Planning Application Comments

Planning Application Number: 20/03660/REM

Drawing Number(s): 201-P102 Rev A

Site Name: Stone Pitts, Hempton Road, Deddington

DRAWING TITLE:  
PLOT 19-21  
ELEVATIONS AS PROPOSED

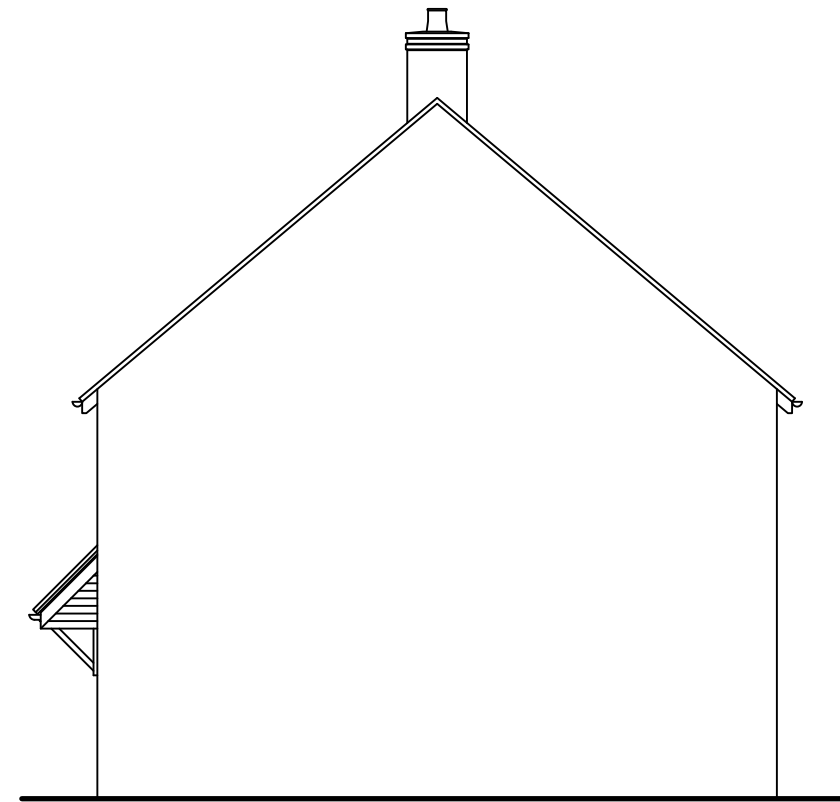
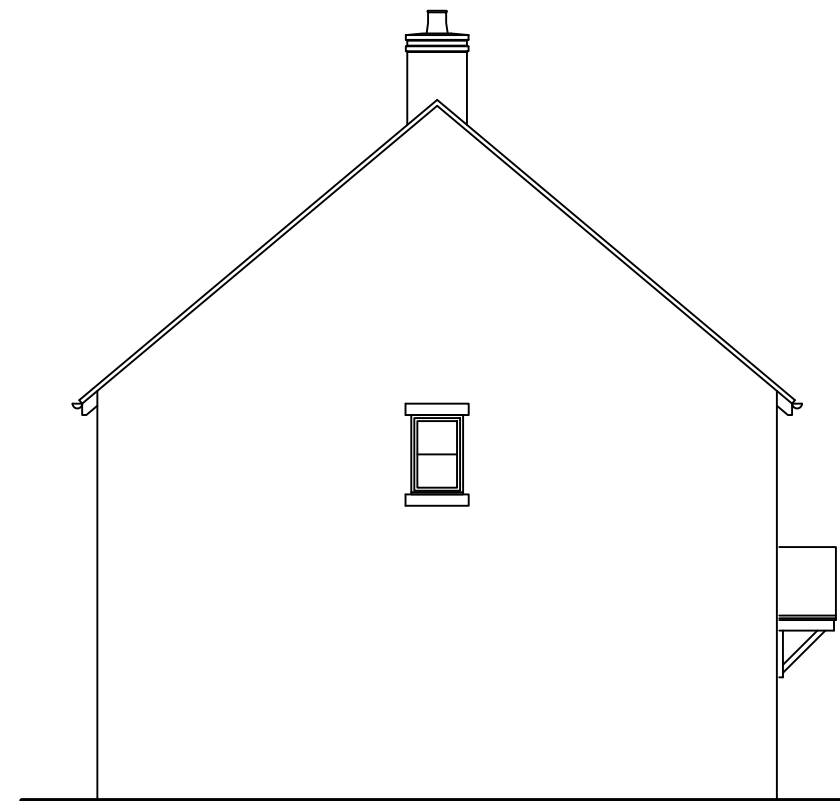
One element that should be considered is bins. With no outdoor space, it is not clear where Plot 18 is supposed to keep their bins; this is not detailed in the elevation drawing. It looks as though Plots 19, 20 and 21 will need to leave their bins in the car parking area for collection on bin day which could potentially clash with parked cars.
